Consultation Response from Alan Smith, KC Waste Strategy (Refuse & Recycling)
2025/92997 Holy Trinity Church, Trinity Drive, Denby Dale, Huddersfield, HD8 8UZ
Change of use and alterations to convert from place of worship to a community workshop and café, erection of external teaching space, external seating area and installation of temporary container storage
Date Responded: 07/05/2026
Responding Officer: Alan Smith
Responding Ref: WPN 26 020

**Proposed Elevation 2**

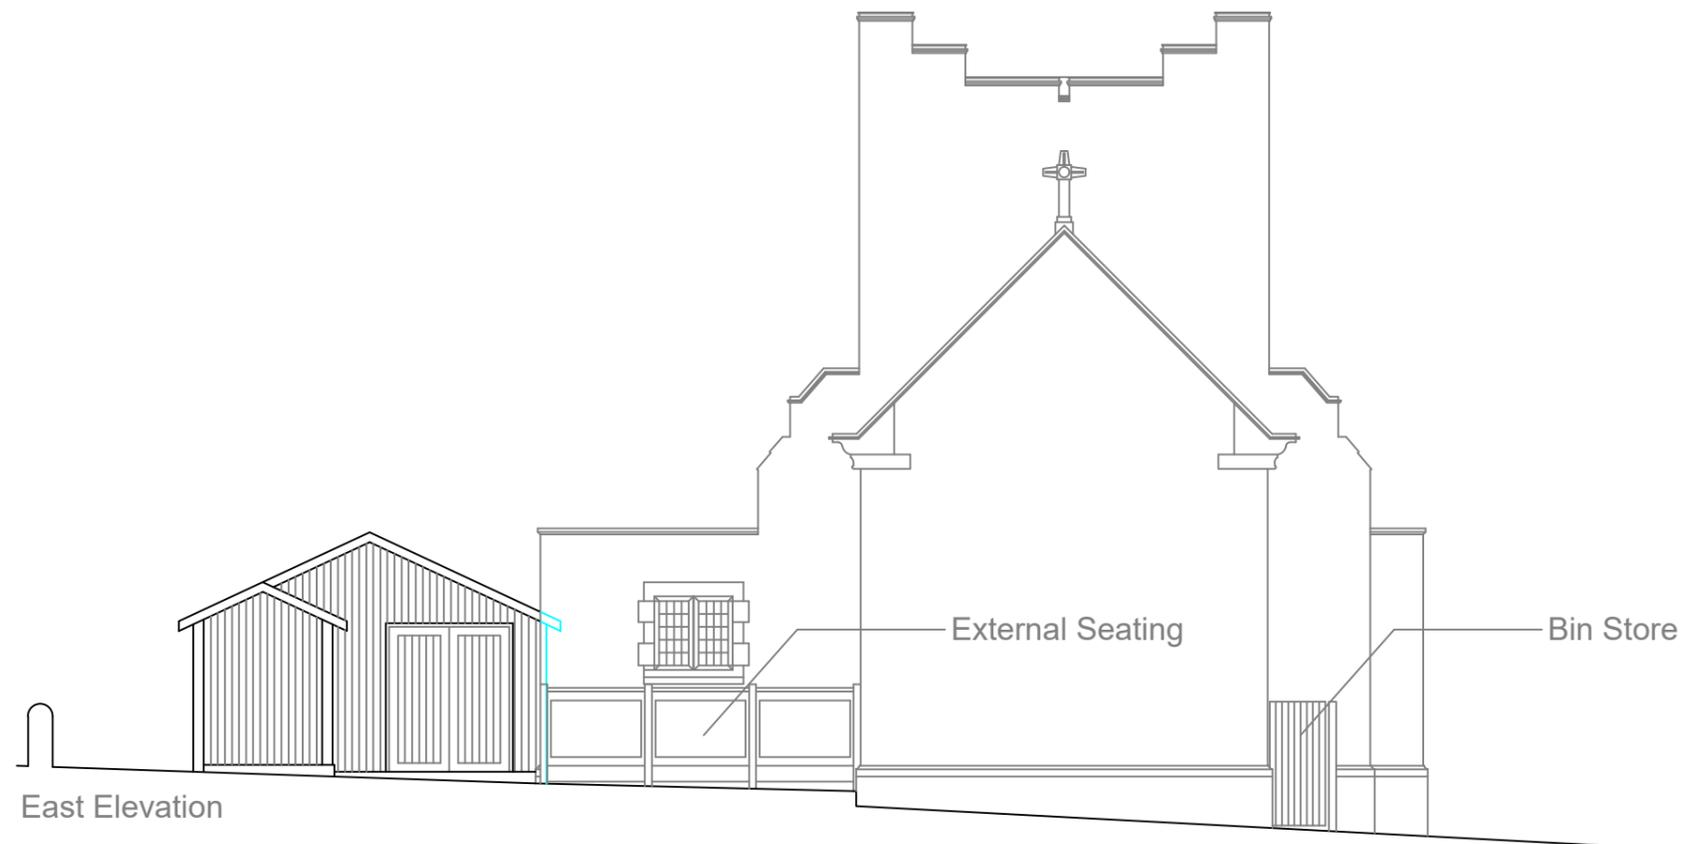
- **3 x 240 L wheeled bins for:**
 - Residual waste – collected on alternative weeks
 - Recyclable waste – collected on alternative weeks
 - Garden waste – paid for service collected fortnightly (or future Simpler Recycling legislation provision)
- **Bin space dimensions:**
 - floor space required is 940 mm x 780 mm per bin
- **Bin storage location:**
 - Must not obstruct highways or driveways
 - No gradients steeper than 1:12 or steps
 - Minimum 2.5 m clearance from fire exits, doors, and windows
 - If 2.5 m clearance is not feasible, adjacent structures must be fire-resistant to 30 minutes
 - Bin store must be secure to prevent theft, unauthorised use, fly-tipping, or rough sleeping
- **Internal segregation:**
 - At least 25 to 40 L internal space within each dwelling for segregation of residual waste, recycling and food waste

- Must be shown on a layout plan for all properties – adjacent to the junction of Trinity Drive and Dearnside Road
- No gradients steeper than 1:12 or steps from storage area to BCP
- Located adjacent to an adoptable highway- adjacent to the junction of
- Solid surface required, resistant to constant wear and tear

# Appendix 1.0 Site Plan Vehicle Tracking

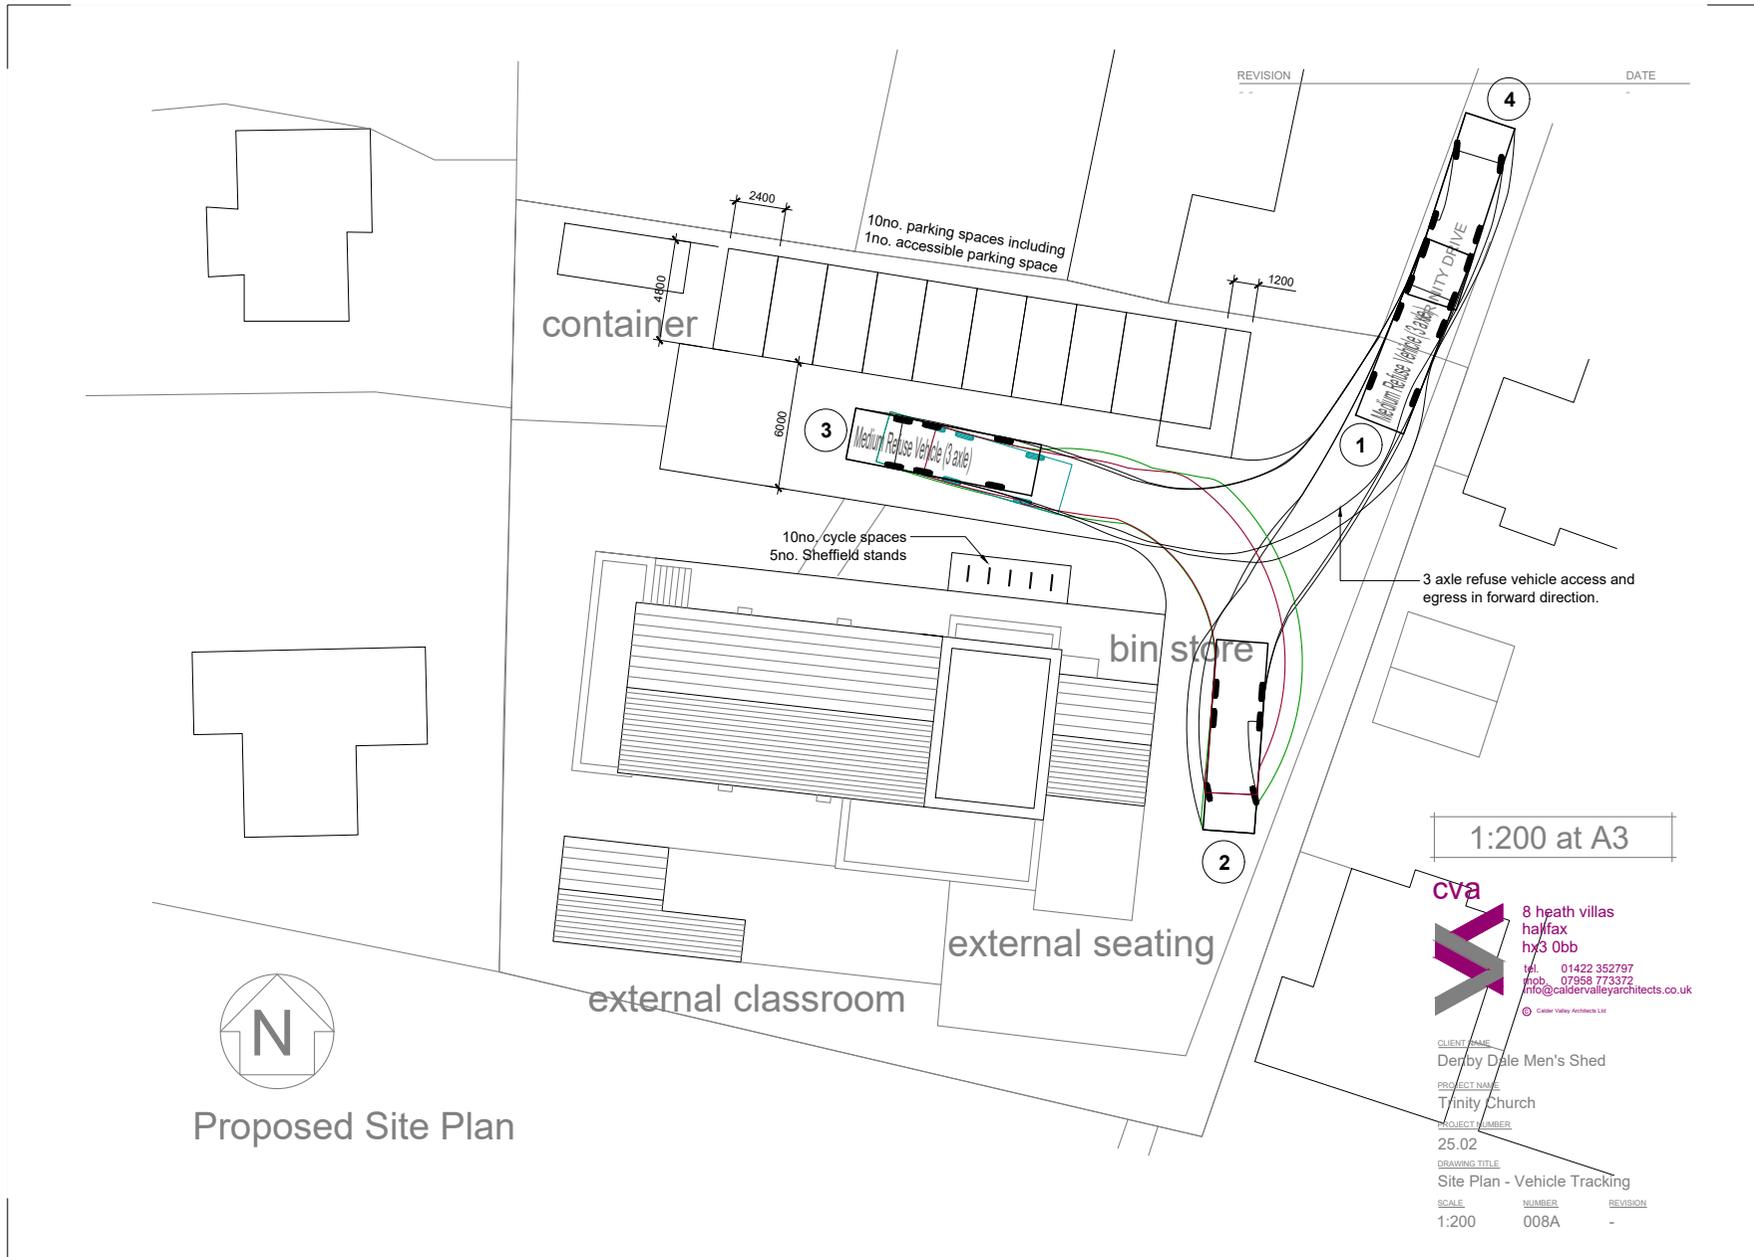
- The WCA will not enter:
 - Private drives
 - Roads not built to an adoptable standard
 - Active construction sites
- Reversing distance for an RCV must not exceed 12 m (WISH guidance)
